**NOTICE OF INTENT TO PROSECUTE**

RE: 18 Hill Street, Units 1-4  
CBL054 C002001  
CBL054 C002002  
CBL054 C002003  
CBL054 C002004

**Inspection Violations**

<b>Owner/Manager</b> HOLLAND NATHAN		<b>Inspector</b> Daniel Dyer	<b>Inspection Date</b> 7/1/2016
<b>Location</b> 18 HILL ST	<b>CBL</b> 054 C002001	<b>Status</b> Failed	<b>Inspection Type</b> Fire Company-FP Routine Inspec

8 Hill St
MATHIAS HOLLAND
Floor Plan 3RD Floor
1/4" = 1'
Fred Dodge
DRAFTED 615-6971

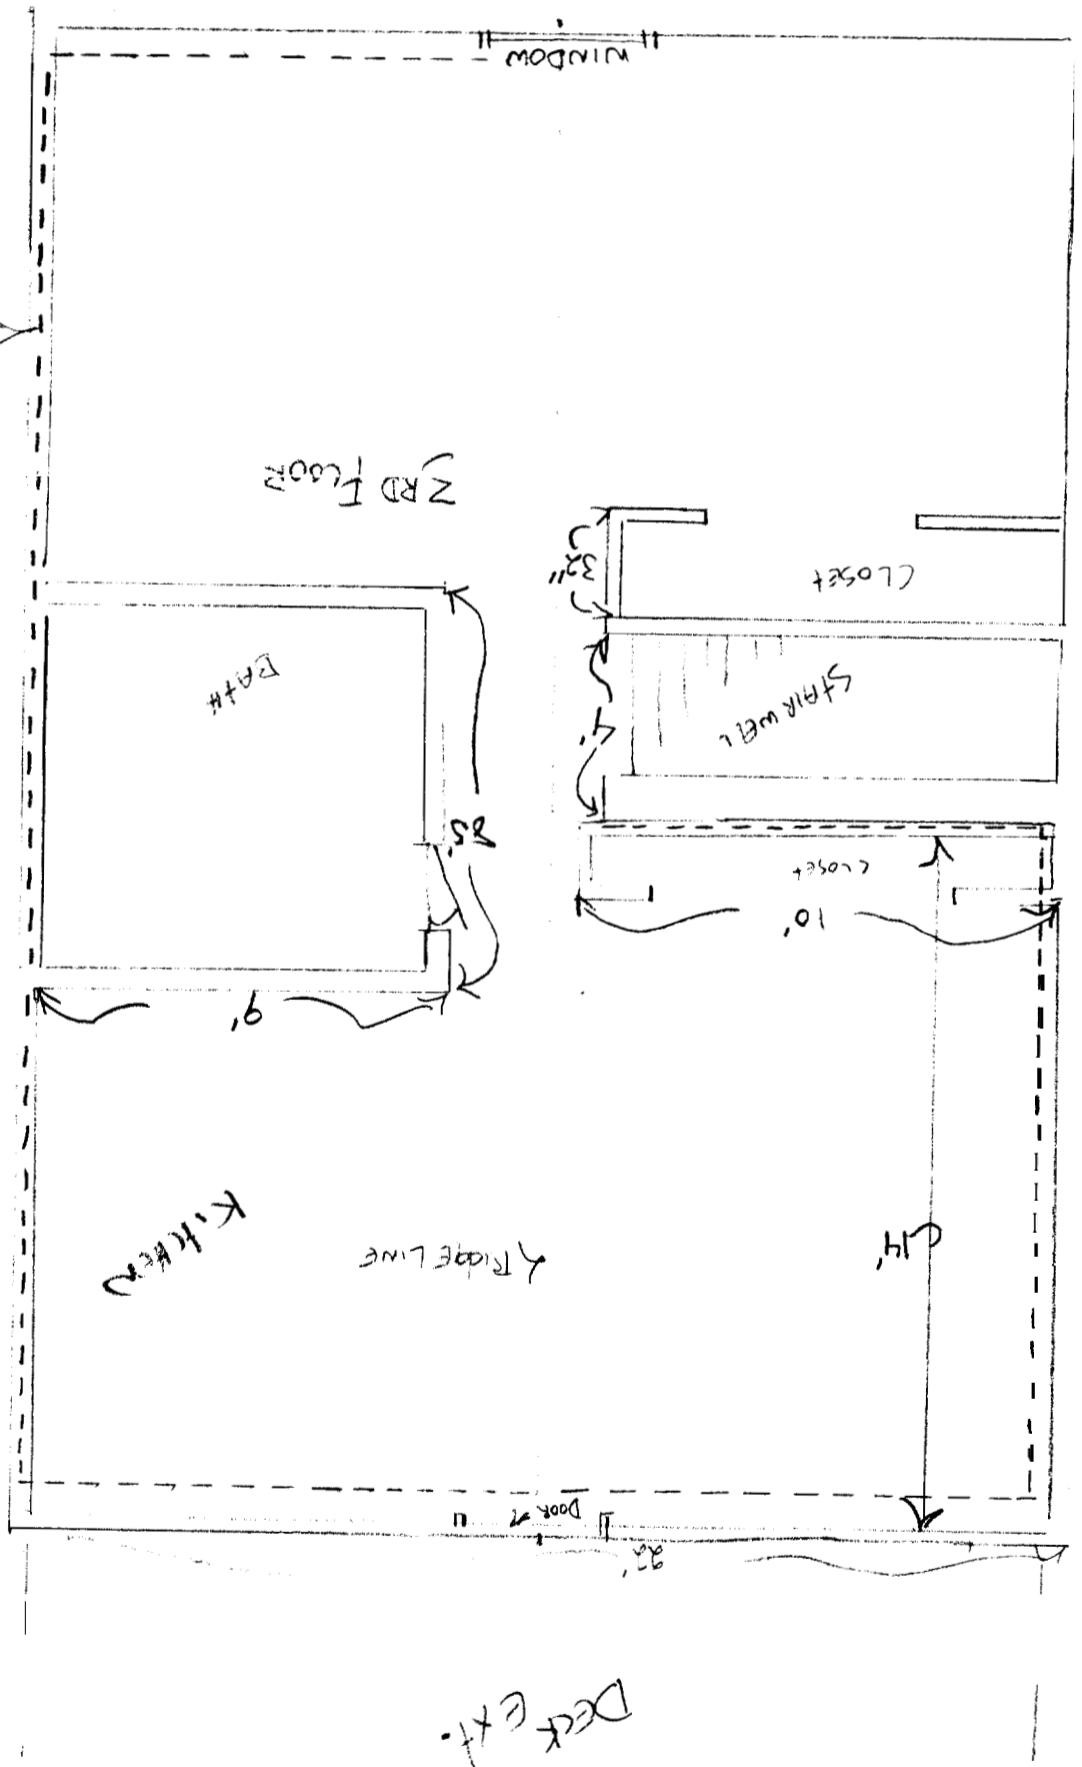
**Violation:** NFPA 101- 7.5.1.1.1 SECOND EXIT REQUIRED; Where exits are not immediately accessible from an open floor area, continuous passageways, aisles, or corridors leading directly to every exit shall be maintained and shall be arranged to provide access for each occupant to no less than two exits by separate ways of travel, unless otherwise provided in 7.5.1.1.3 and 7.5.1.1.4.

**Notes:** UNIT 3, BOTH DOORS ENTER SAME HALLWAY

**Comments:** Entered Apts. 1,2,and 3. All had required detectors. Both exits from apt. 3 enter into the same hallway.
